DESIGN PROFESSIONAL INSPECTION FORM

Residential Single-Family Project: Yes <input checked="" type="checkbox"/>	Commercial Project: _____
Code Enforcement Project No: -----	Permit No: _____
Project Name: Screen Porch Construction	Owner: _____
Project Address: 1039 Jackson Rd, Fuquay Varina, N C 27526	Suite No: _____
Date Inspected: 03/18/2025	Contractor Name: _____
Component Inspected: Foundation Excavation and Approved Plan Review For Header Span Change

Subject: Approved Plan Review for Change in Pier Span and Foundation Subgrade Inspection

RAFTER PLAN

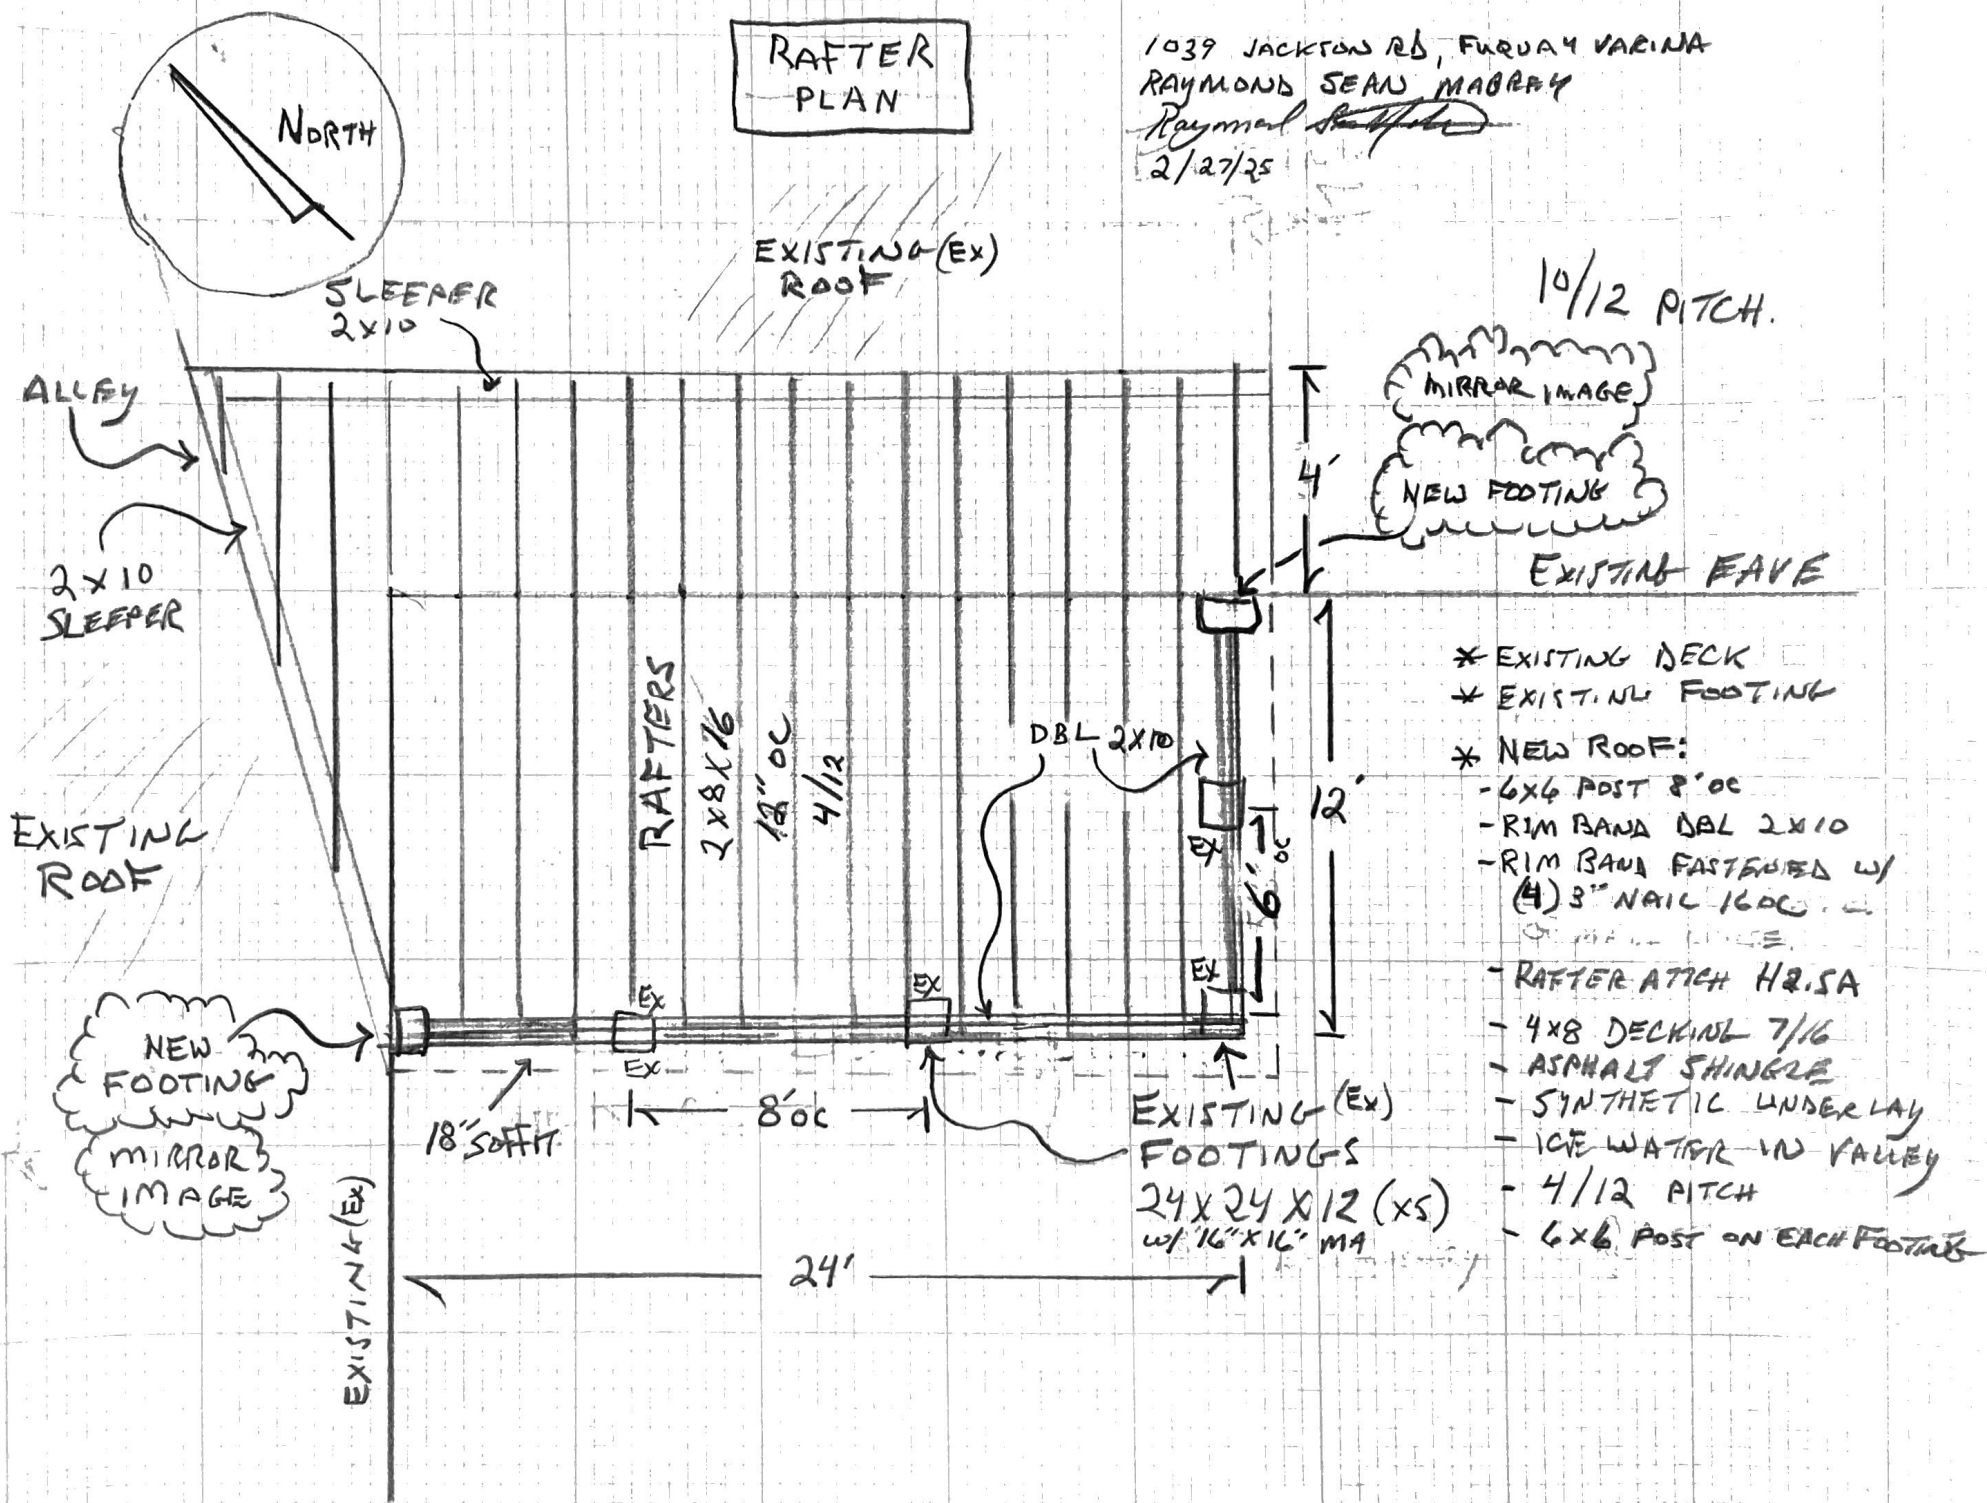
The approved plan was reviewed, in which the Contractor requested moving one foundation to the right (when facing the house), which would change the girder span from 8 feet on-center (O.C.) to 9 feet. Therefore, we recommend using either 3-2x10 or 2-2x12 pressure-treated lumber beams at this location. Refer the attached markup on the approved plan.

Additionally, I personally witnessed the footing excavation on February 18, 2025, at three locations as marked on the attached approved plan. The footings were excavated to a minimum size of 1 foot by 1 foot in plan, with depths ranging from 18 to 24 inches at these locations. The subgrade soils at these locations were residual and competent. A probe test confirmed that the foundation was stable, with the probe driving no more than 2 inches at all three locations.

All three foundations are adjacent to the existing foundation. I recommend installing a minimum of two dowels at each location to connect the new foundation with the existing foundation. The dowels should be #5 rebar with a minimum embedment of 6 inches into the existing foundation, and high strength anchoring epoxy should be used to secure them in place.
